CITY OF ALBUQUERQUE

RE: 13704 Ellena Gallegos NE
Grading Plan
Stamp Date: 7/18/17
Hydrology File: E24D002A

SITE HYDROLOGY

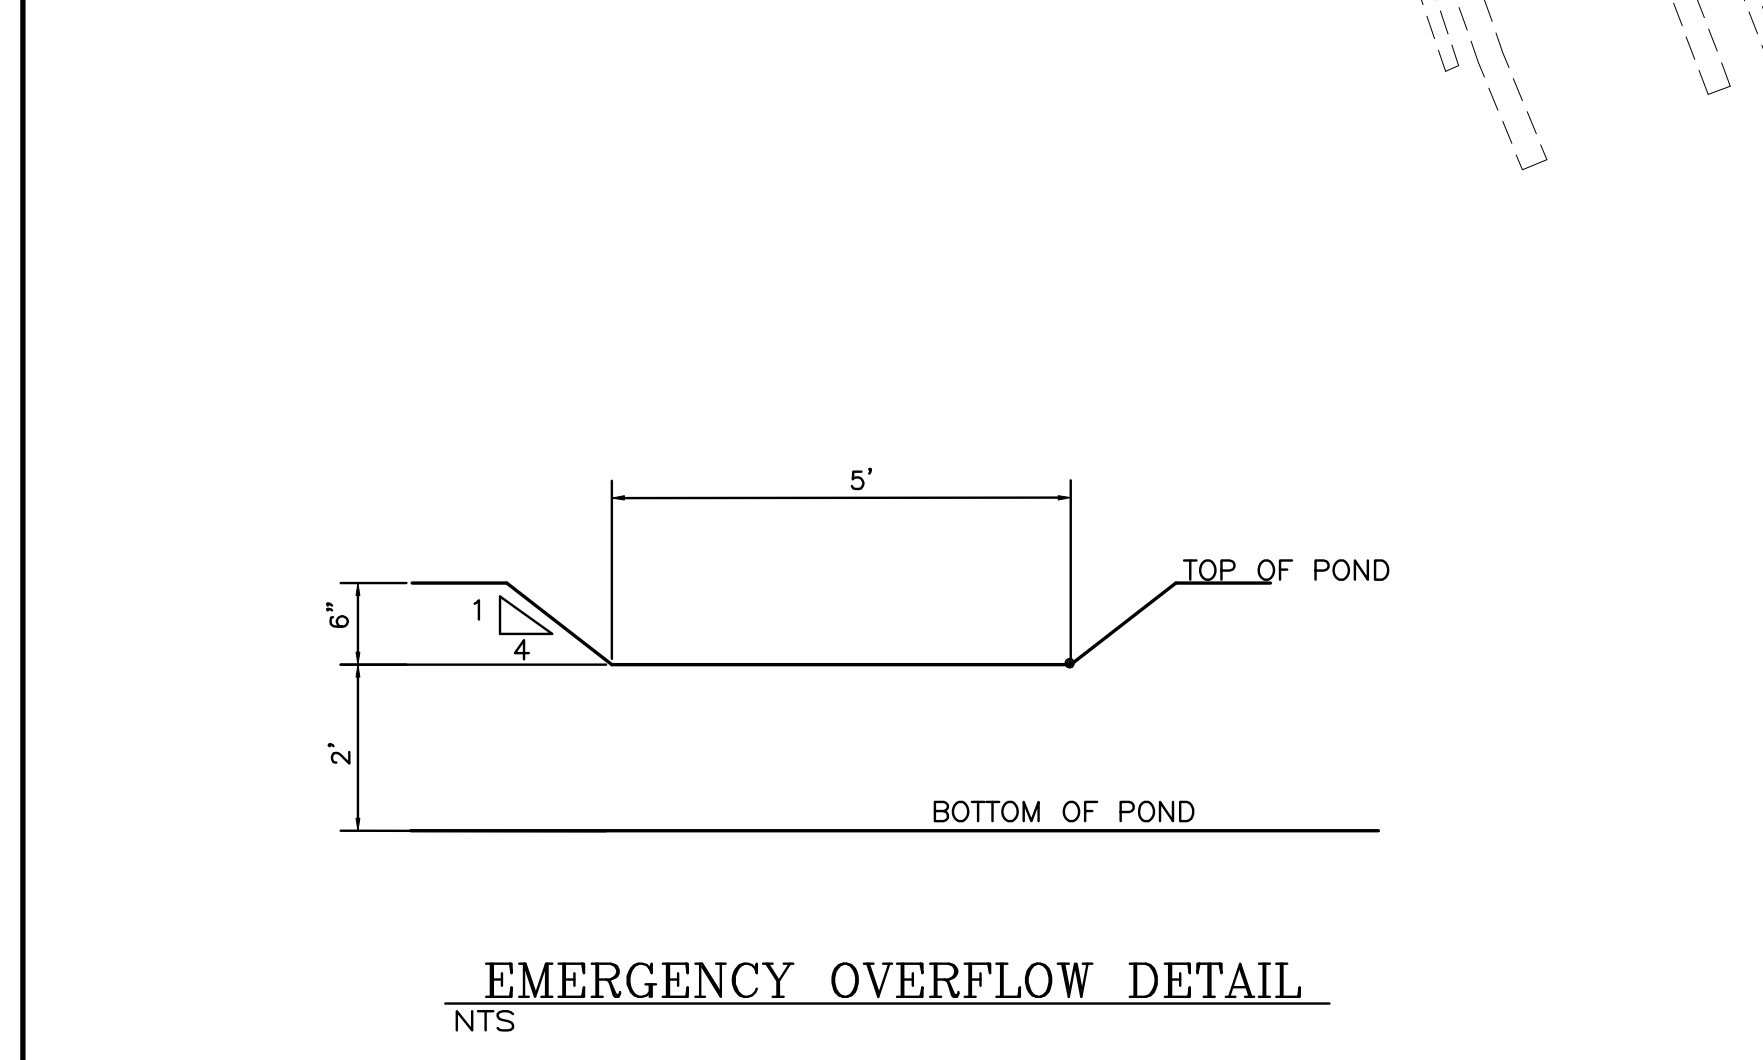
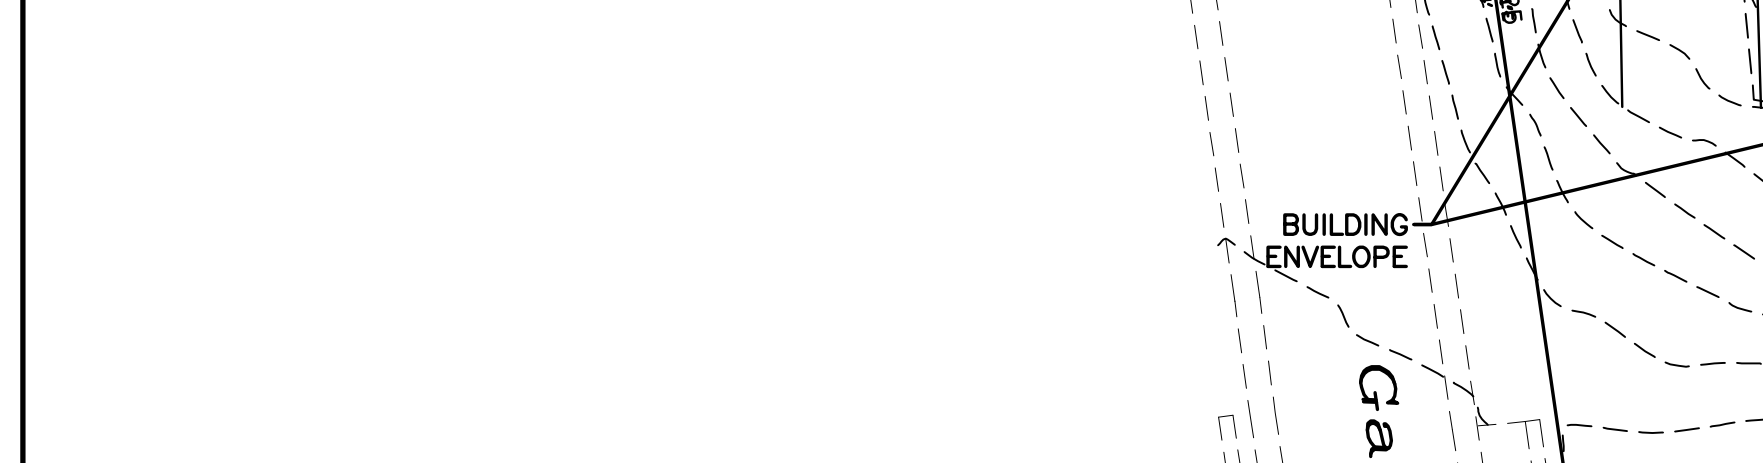
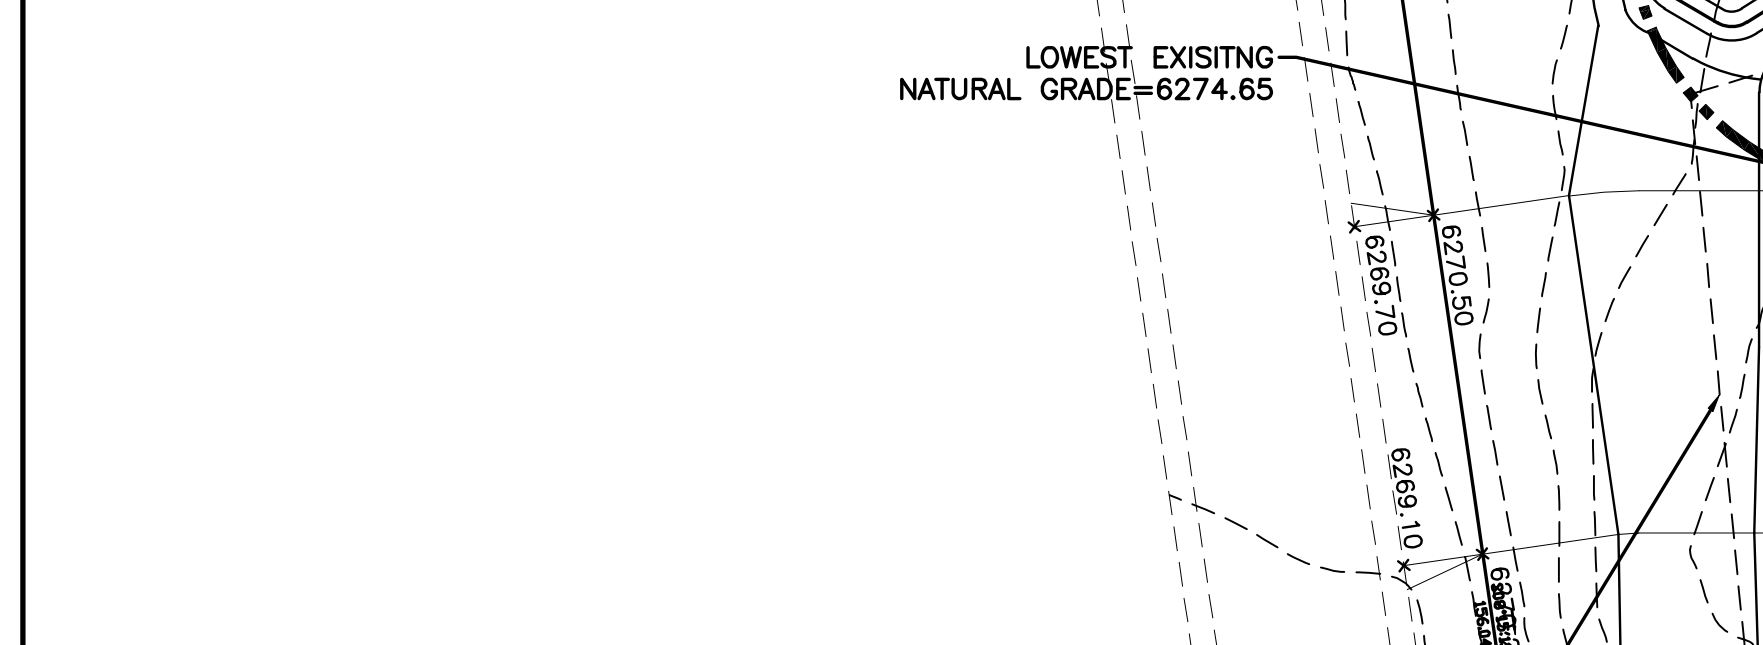
1. Please provide both the beginning and ending flowlines for all the cobble swales.
2. Please add the weir calculations for the emergency overflows.
3. There is enough room on the sheet, so please enlarge the Site Hydrology calculations and notes.
